**Aquind Interconnector Nationally Significant
Infrastructure Project Examination: Deadline 8 (1 March
2021)**

Final Comment at Deadline 8

Main Submission Paper

Aquid Countryside Option

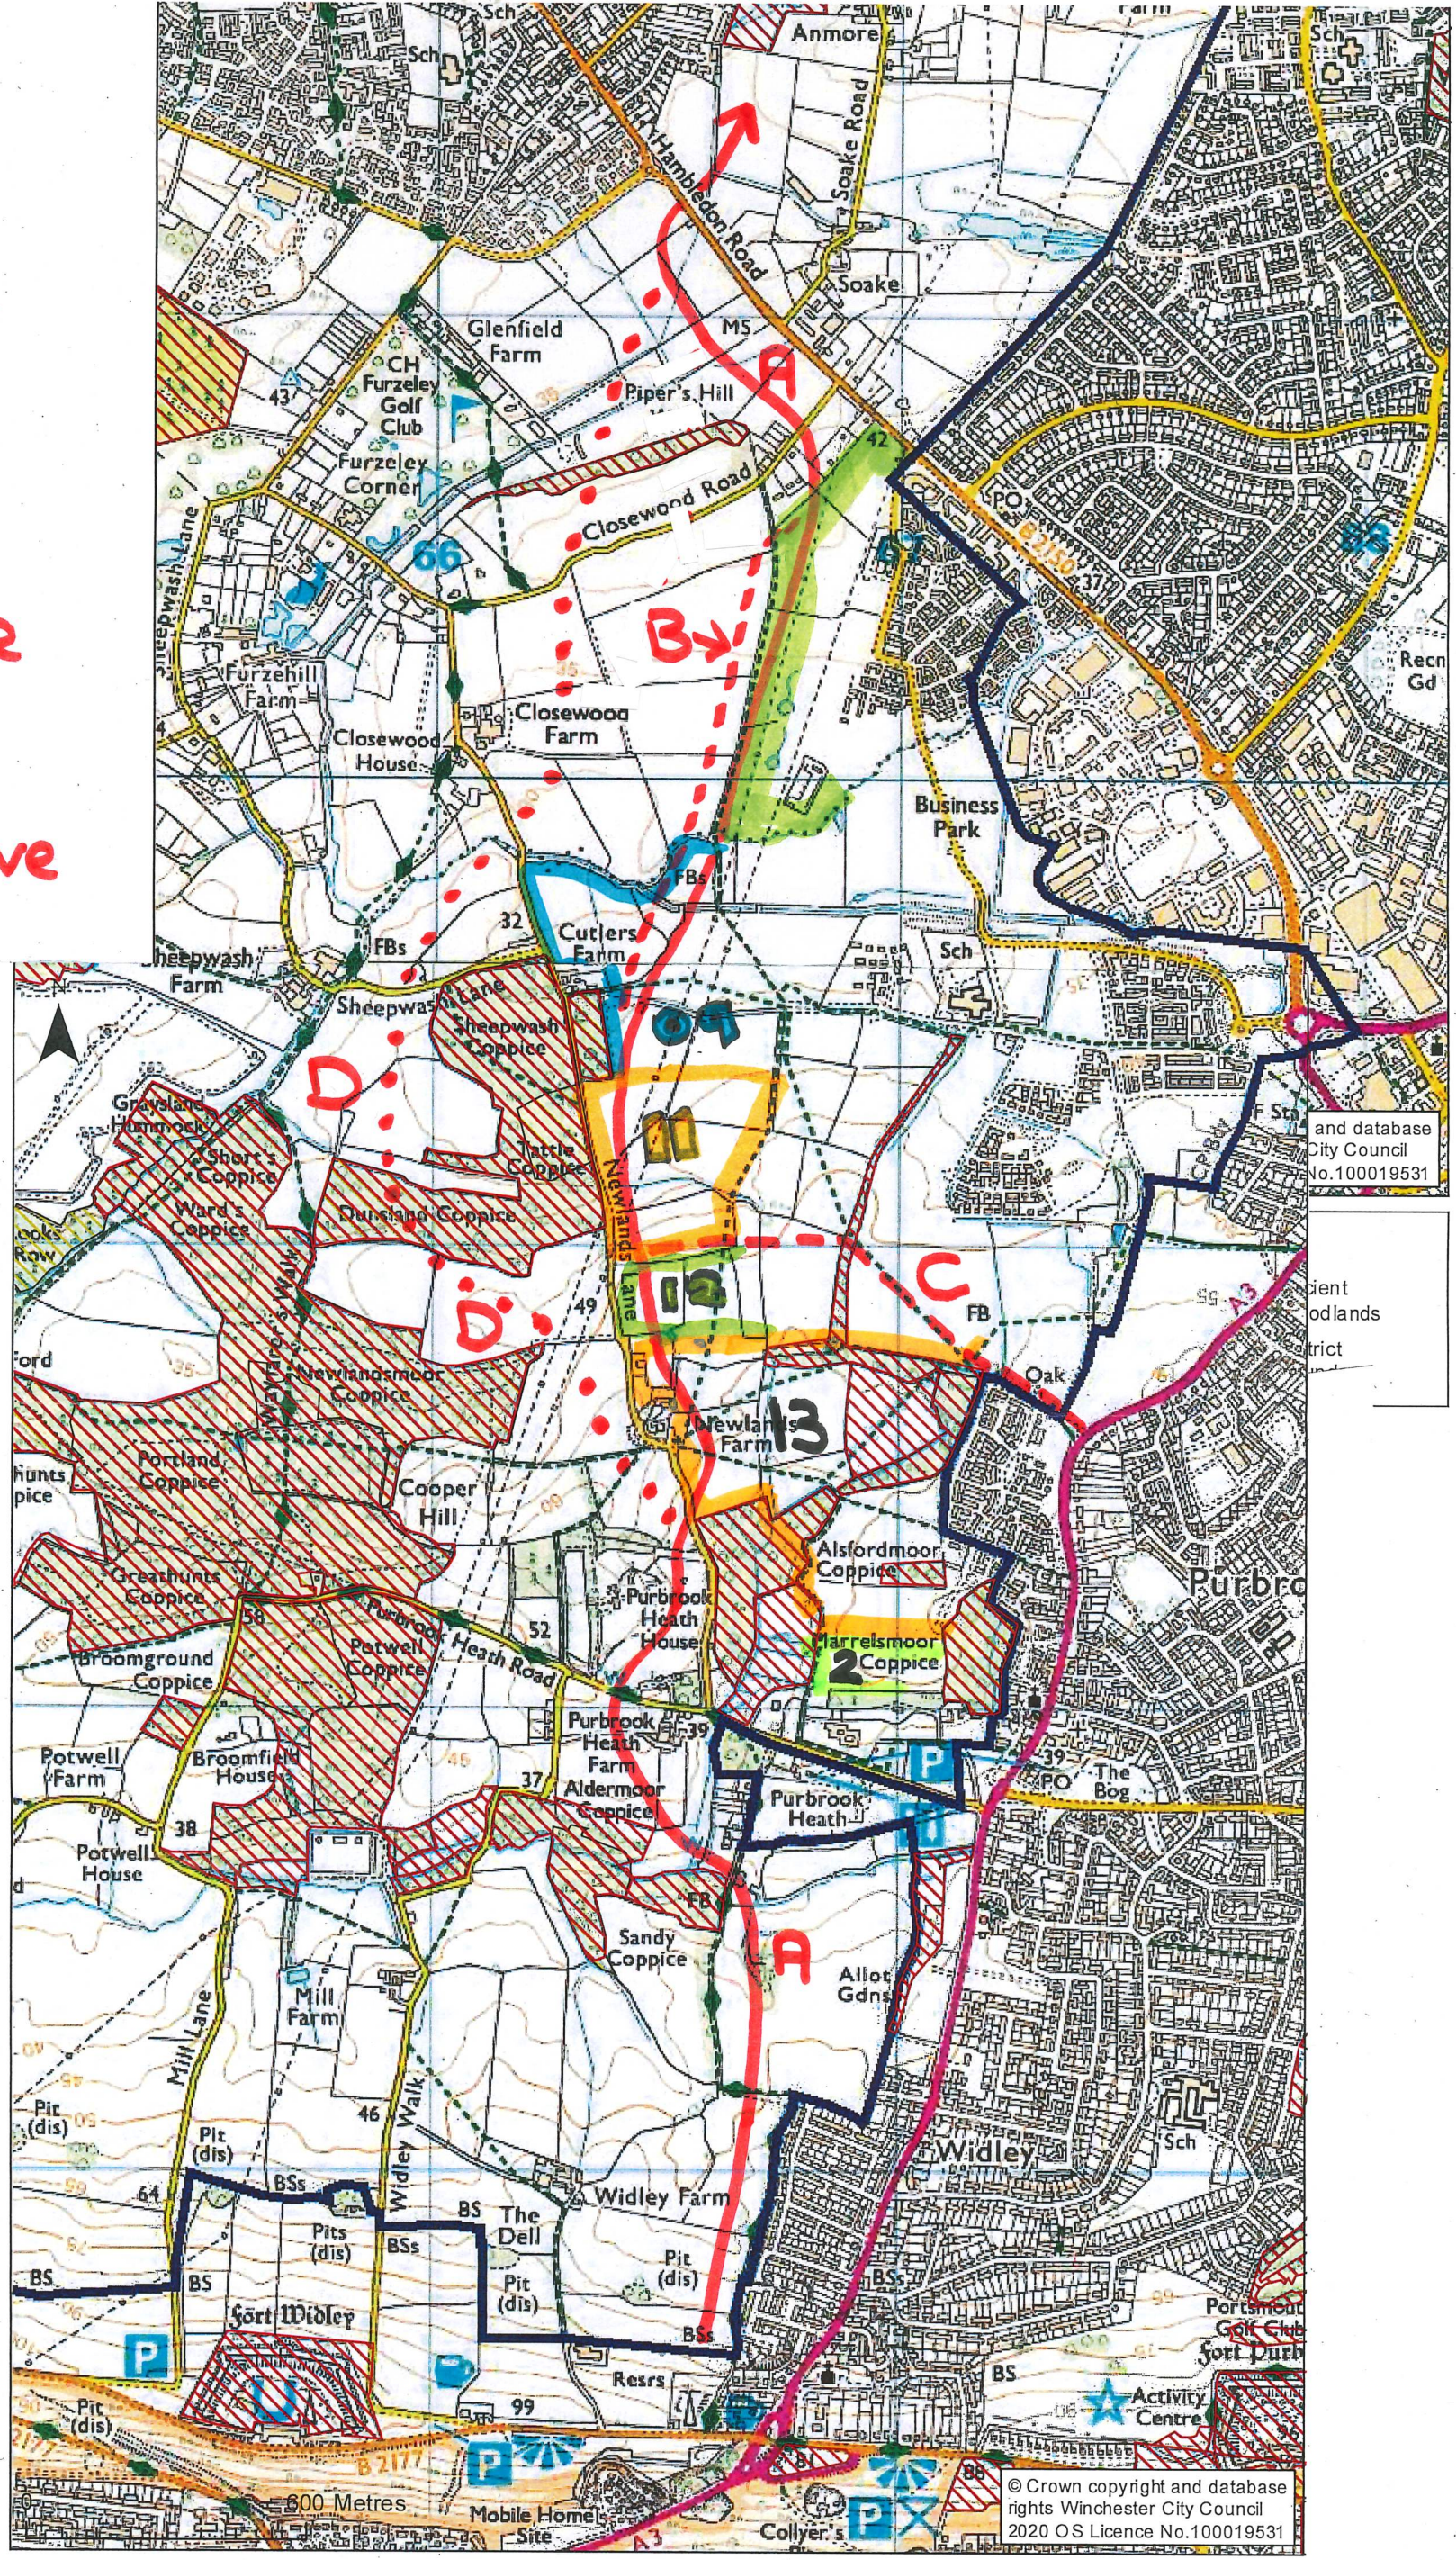
- 11.1 Throughout the entire application process, the Council has been seeking clarification on the consideration that the applicant gave to taking the cable route across the open countryside from Portsdown Hill up to the Hambledon Road as opposed to following the A3 and B2150. This search for an answer has been undertaken whilst discussions on the various impacts of laying the cable circuits in the highway have been considered. Whilst those impacts may well have reached a point where they are “agreed” that does not diminish the merits of considering an alternative which if adopted would remove the majority of impacts entirely.

- 11.3 The reason why the Council has persisted in responding on this matter is simple. In none of the evidence submitted by the applicant have they addressed the core question. This is summarised below as follows:

- 11.4 None of the applicant’s responses has dealt with this question directly. The most comprehensive response at deadline 1 the Supplementary Alternatives Chapter (REP1-152) devotes a whole section (section 8) to what is referred to as the Countryside Route. This section contains an assessment of the issues that such a route would need to address but it does not respond to the core question and provide the timeline sought which would show that this option was part of the assessment when the applicant was looking for the best route to link Eastney to Lovedean.

- 11.6 In the light of the responses, the inevitable conclusion after 6 months is that the applicant did not consider the Cross Country Route when they were looking for a cable route to connect the landfall to the grid connection point. The Council's letter at PDB 2 noted the applicant's stated strategic intention from August 2014 as outlined in chapter 2 of the ES for the onshore cable route to be laid in the highway. The conclusion is that this principle drove the choice of the A3/B2150 and not some measured assessment of the pros and cons of the road route against the cross-country route. The exercise to assess the relative merits of the cross-country route only took place after April 2019 in response to the questions raised at the PIR stage. By that time the decision to follow the road route was already fixed. Consequently, the most recent information submitted during the Examination has focused on identifying and assessing the constraints associated with such a route to present a case to justify the unsuitability of that route. In effect, it was retrospectively fitting the case to justify why the road route was adopted.
